Mountain View Electric Association, Inc. (MVEA) has these comments about the following:

Project Name: Tanja Curtis Minor Subdivision

Project Number: MS 195

Description: It is proposed to develop Curtis Subdivision, Filing #1 with two (2) single family residential lots on an approximately 37 acre parcel located on the northwest corner of Roller Coaster Road and Baptist Road. This proposed development is located in Section 21, Township 11 South, Range 66 West.

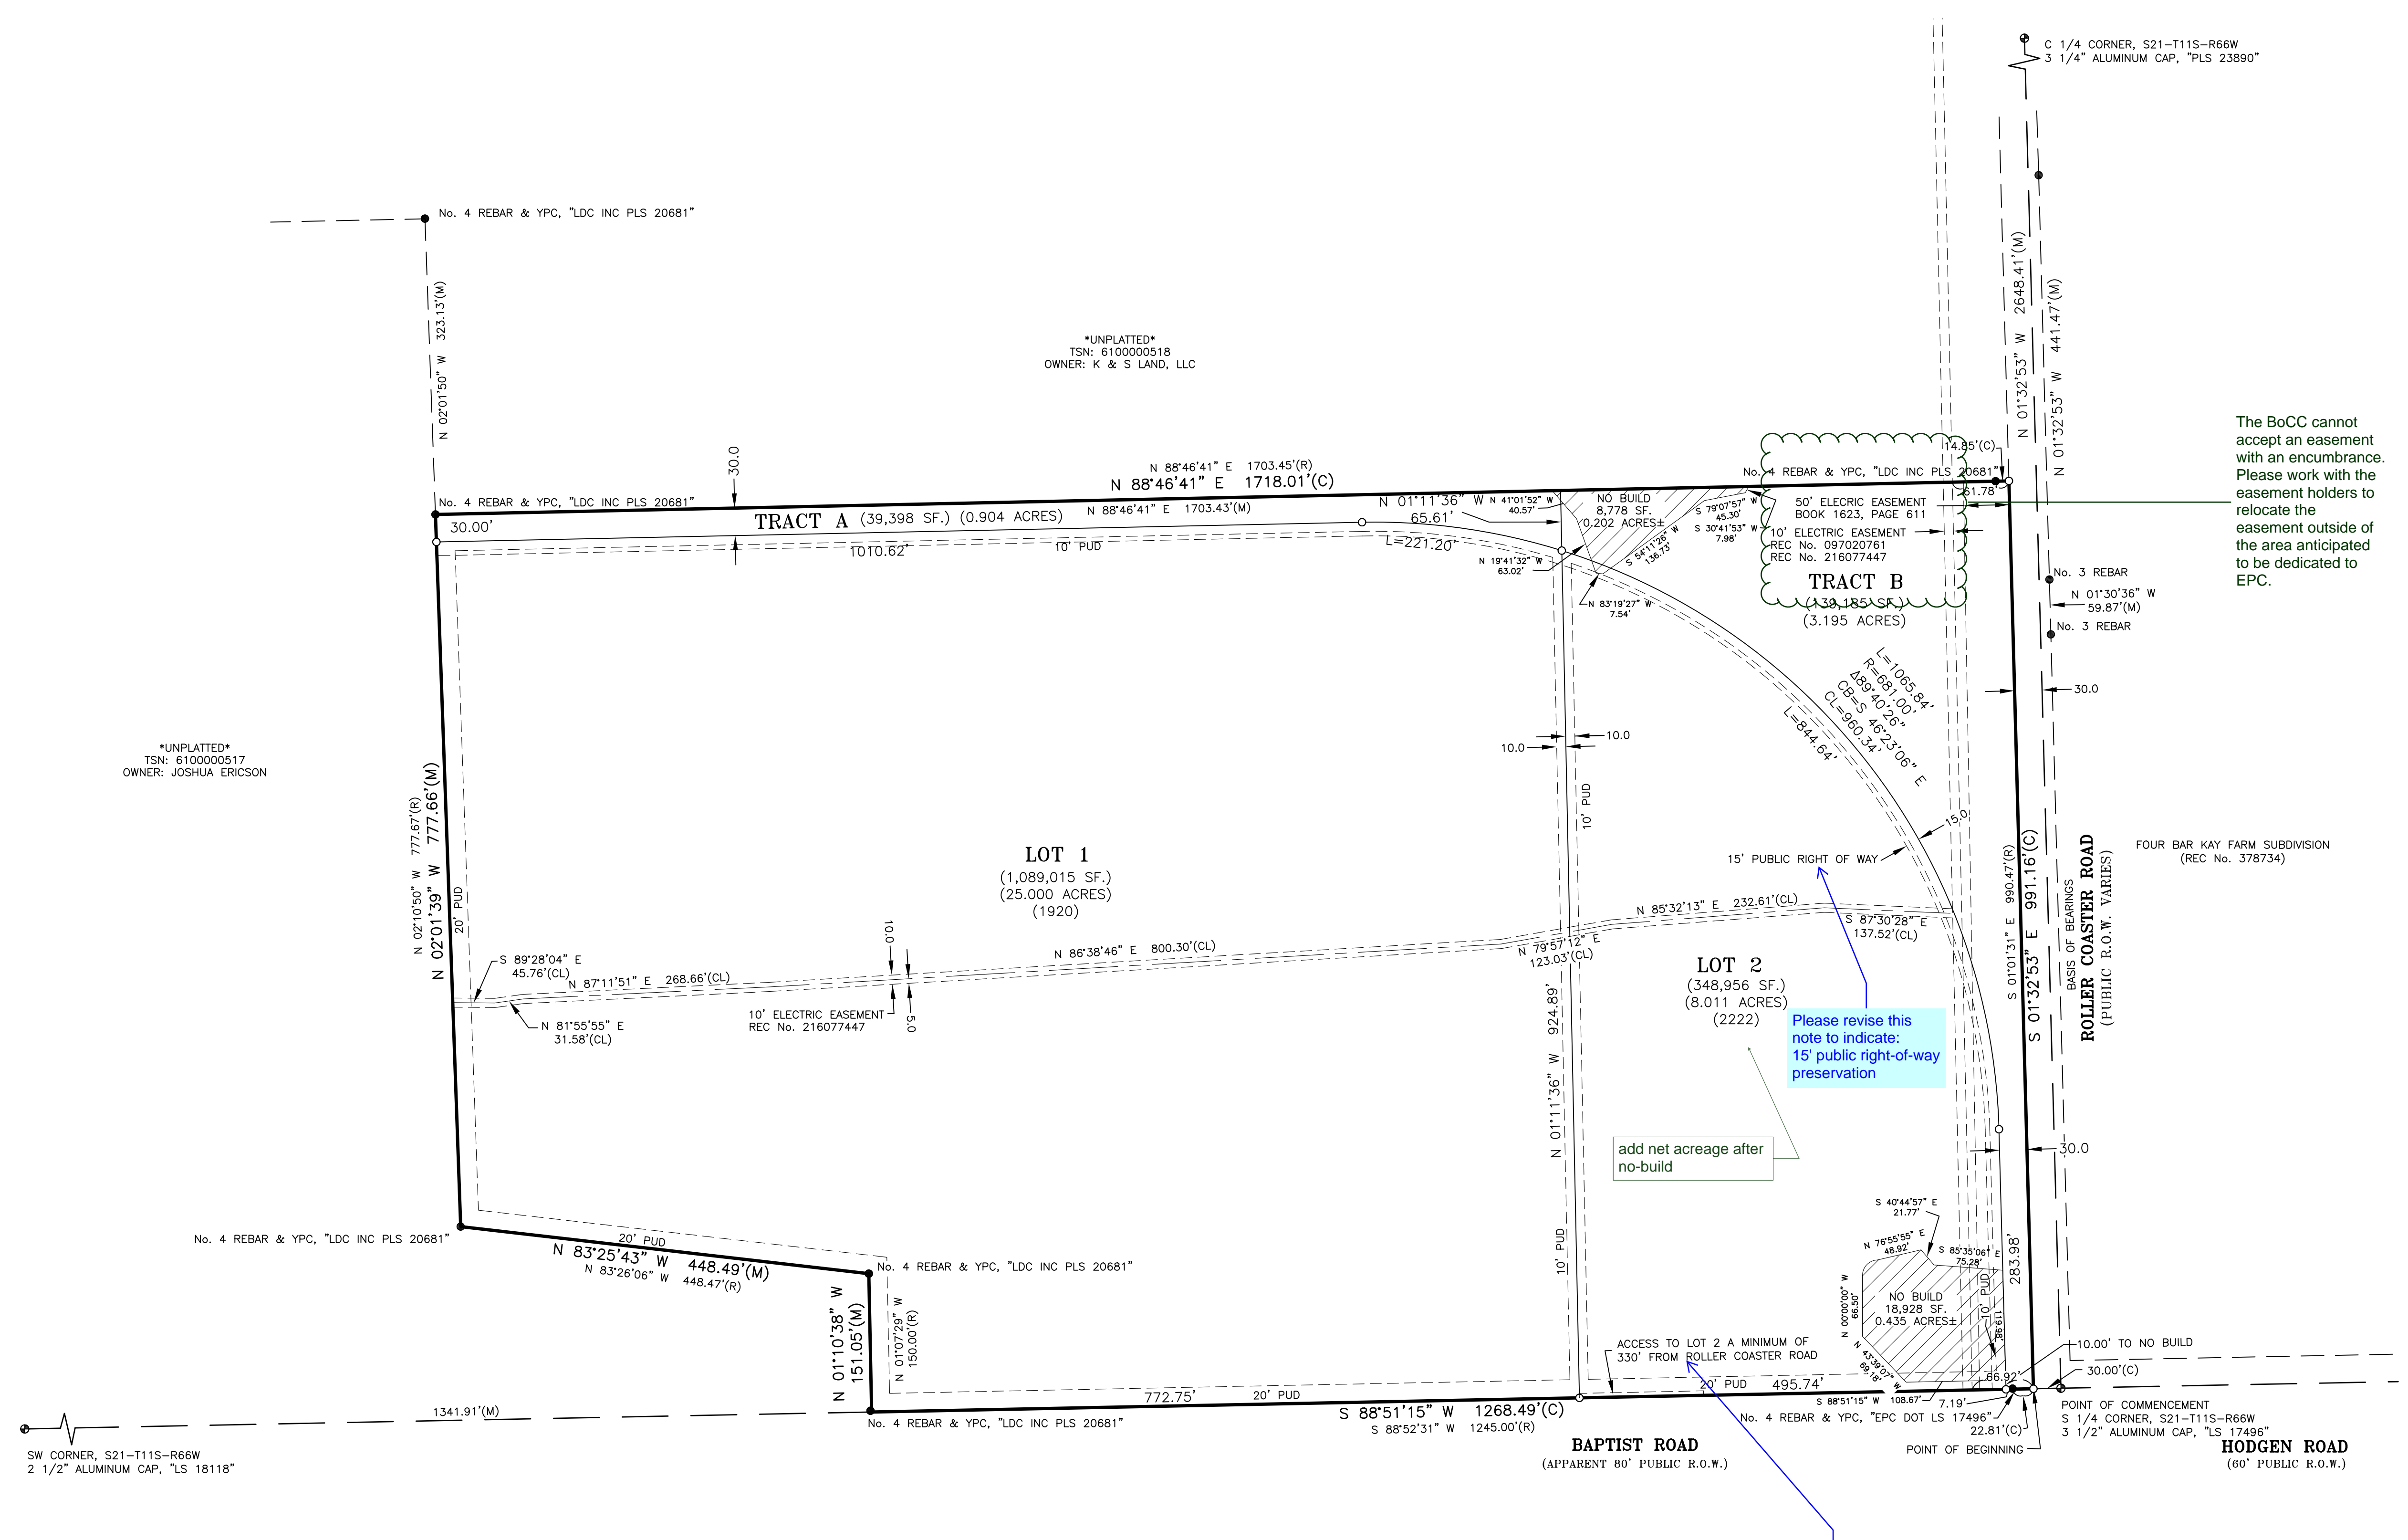
MVEA request the plat be corrected to show the recorded MVEA utility easement #216077447 as twenty (20) foot, being ten (10) foot each side of the existing electric facilities.

MVEA request ten (10) foot along the common side lot line and a twenty (20) foot exterior utility easement on plat. MVEA also requests platting of existing MVEA facilities with easement on the plat. Additional easements may be required once a review of civil drawings with grading and erosion plan is provided to MVEA.
